Online Comment

Application H16-0689-24
Location Water Lane Nursery Low Road Spalding PE12 6EF
Proposal Demolition of existing agricultural barns and greenhouse and erection of residential development

Name Ruben Lopez Catalan
Address Lincolnshire County Council, County Offices, Newland, Lincoln LN1 1YL
LN1 1YL

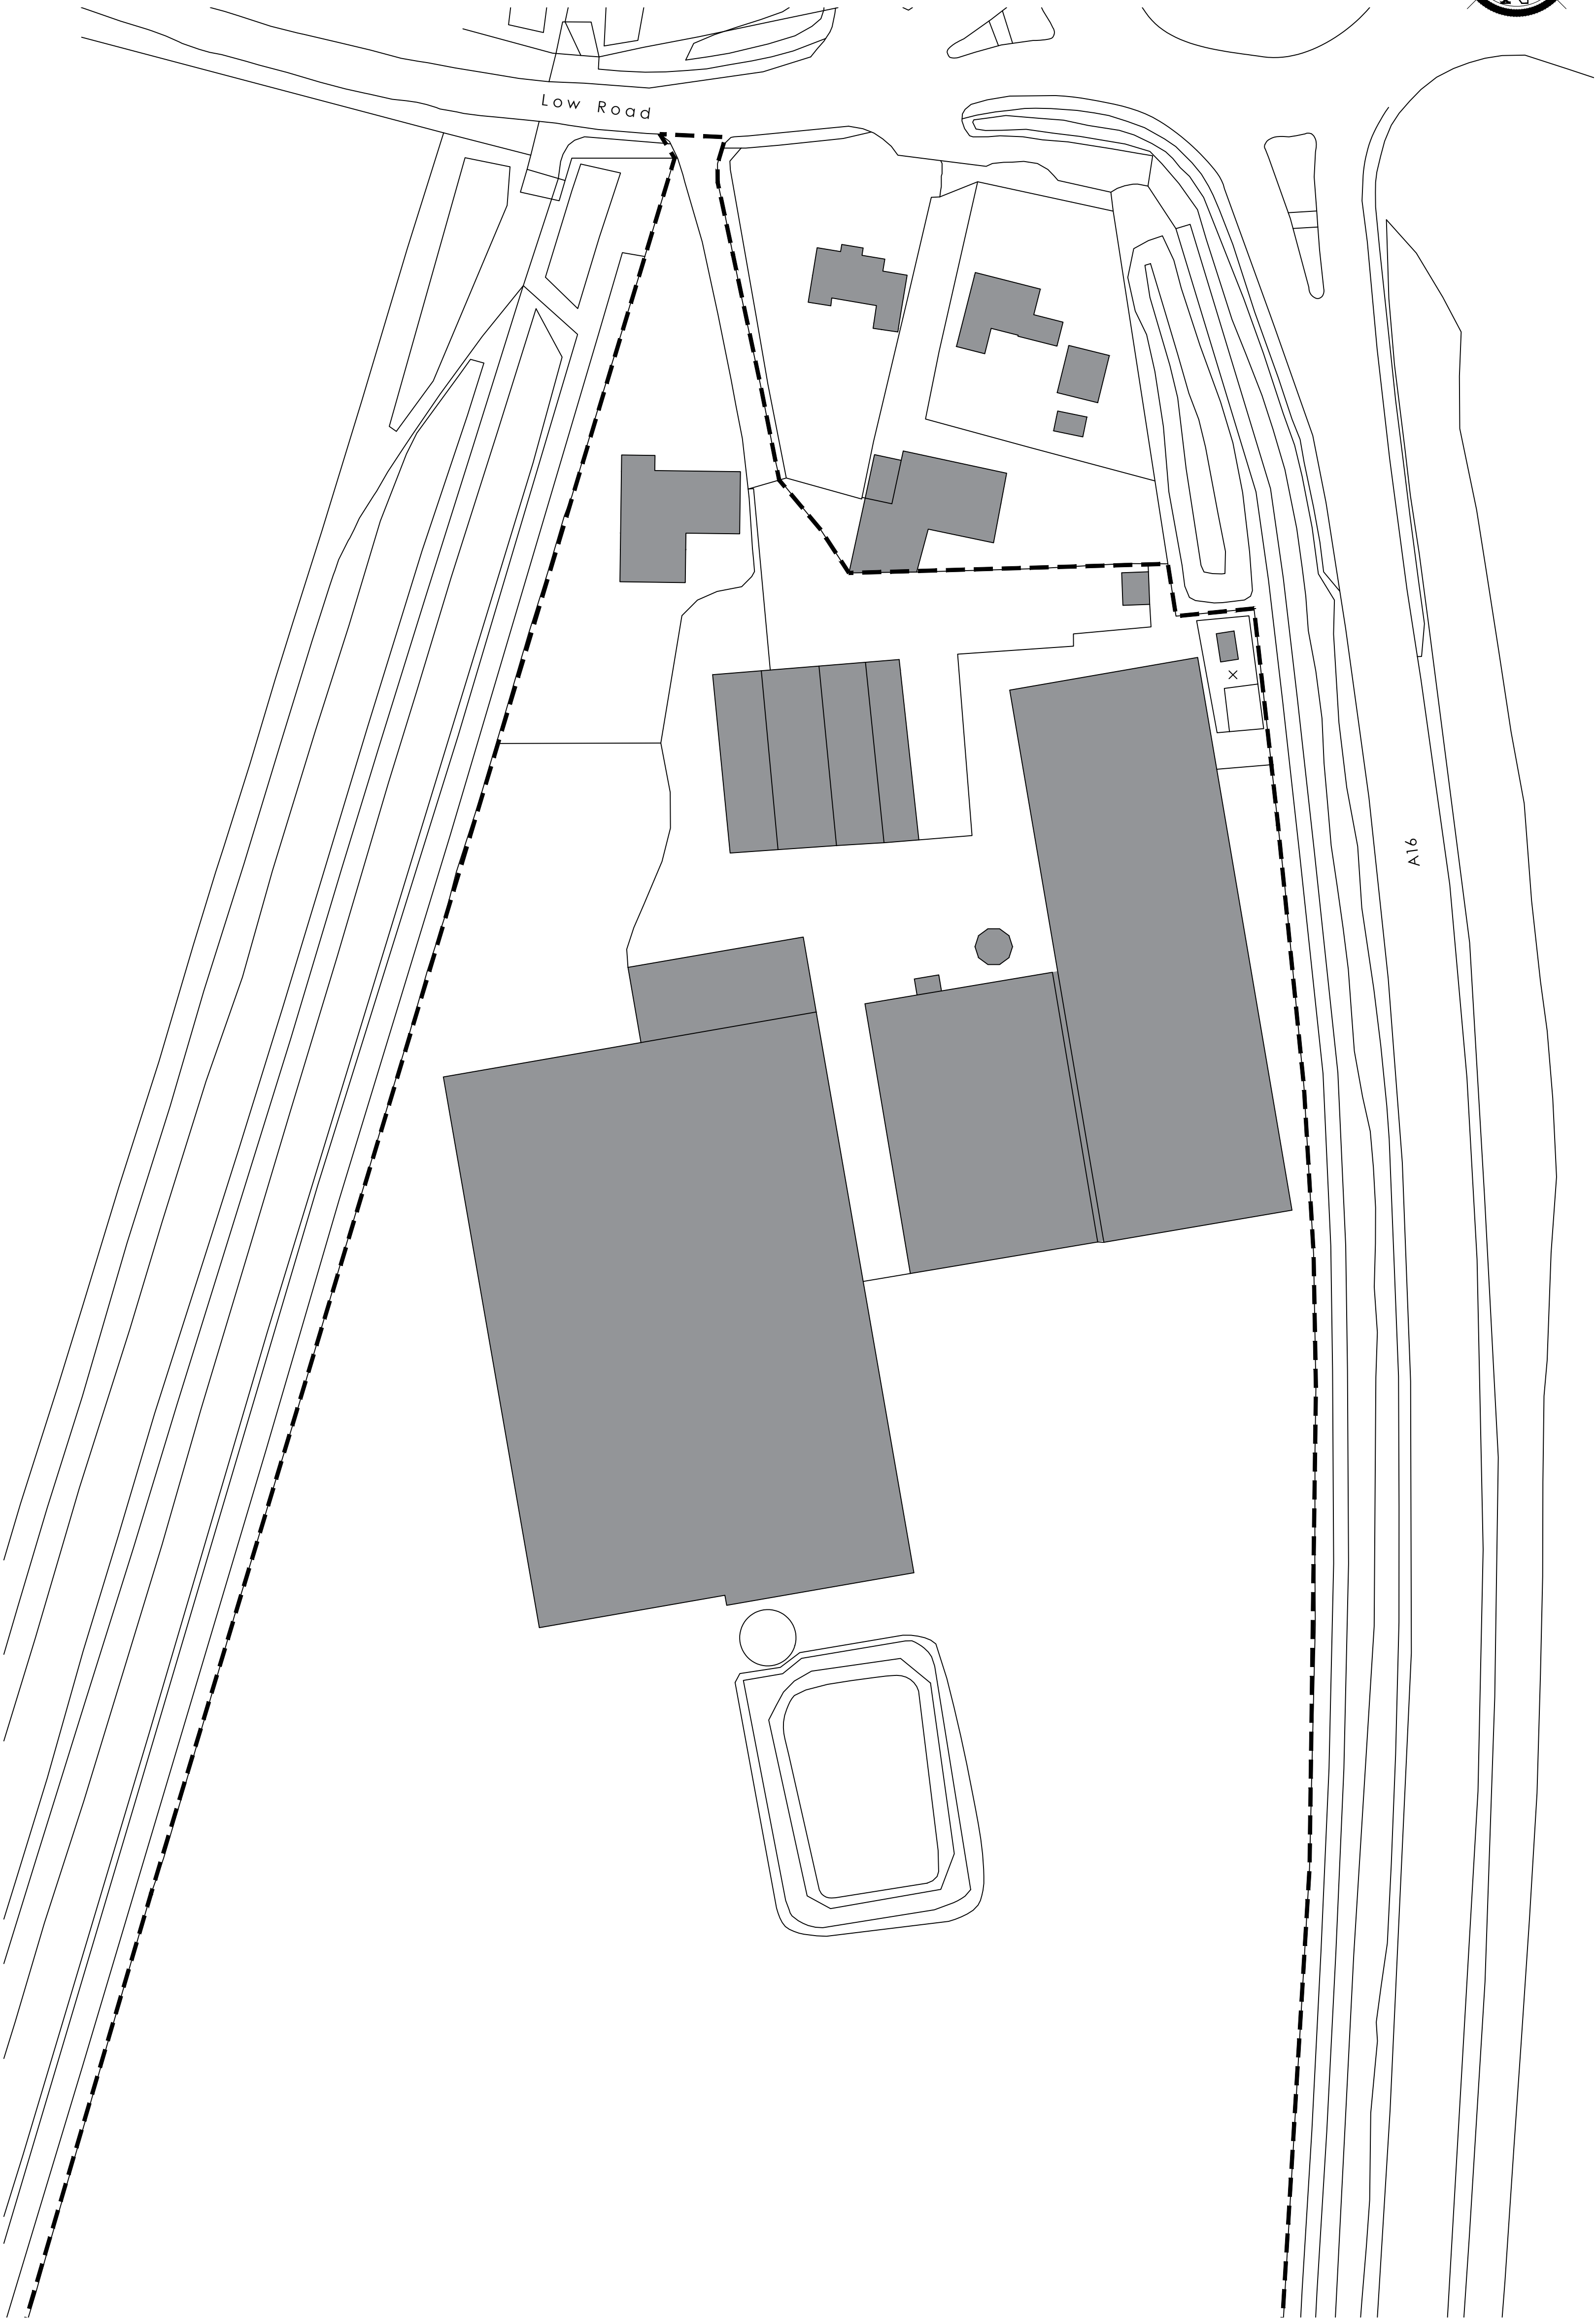
The barns are part of a partially extant 19th century farmstead: Monument record MLI22764. In addition, it is included in the 'Building the Evidence Base for Historic Farmsteads in Lincolnshire'. This project mapped Lincolnshire's historic farmsteads (defined as those that pre-date the 2nd edition Ordnance Survey mapping of the early 1900s). The barns structural condition surveys which accompany the application rightly identifies that "The exact date of construction is unknown."

It is noted that the applicant has not yet provided an assessment of the archaeological or heritage potential of the site, as outlined in the NPPF (paragraph 200).

The proposed development comprises "Demolition of existing agricultural barns and greenhouse and erection of residential development". The proposed development groundworks and any temporary works associated with the development will have a significant impact on any surviving archaeological remains, resulting in total or partial loss, if present.

I recommend that if permission is granted, there be an archaeological condition for a mitigation strategy to effectively deal with this site. This will comprise a phased approach of archaeological investigation and mitigation work.

This will initially comprise, but may not be limited to, a HBR of the barns. Also, a geophysical survey to support a trial trench evaluation of the site which should aim to determine the presence, absence, significance, depth and character of any archaeological remains which could be impacted by the proposed development as noted above and to inform a programme of further archaeological mitigation work which may be required if archaeological remains are identified in the evaluation.

This should be secured by South Holland District Council's standard conditions AR01, 02 and 03 and is in accordance with National Planning Policy Framework paragraphs 200 and 211 and the South East Lincolnshire Local Plan (Policy 29).
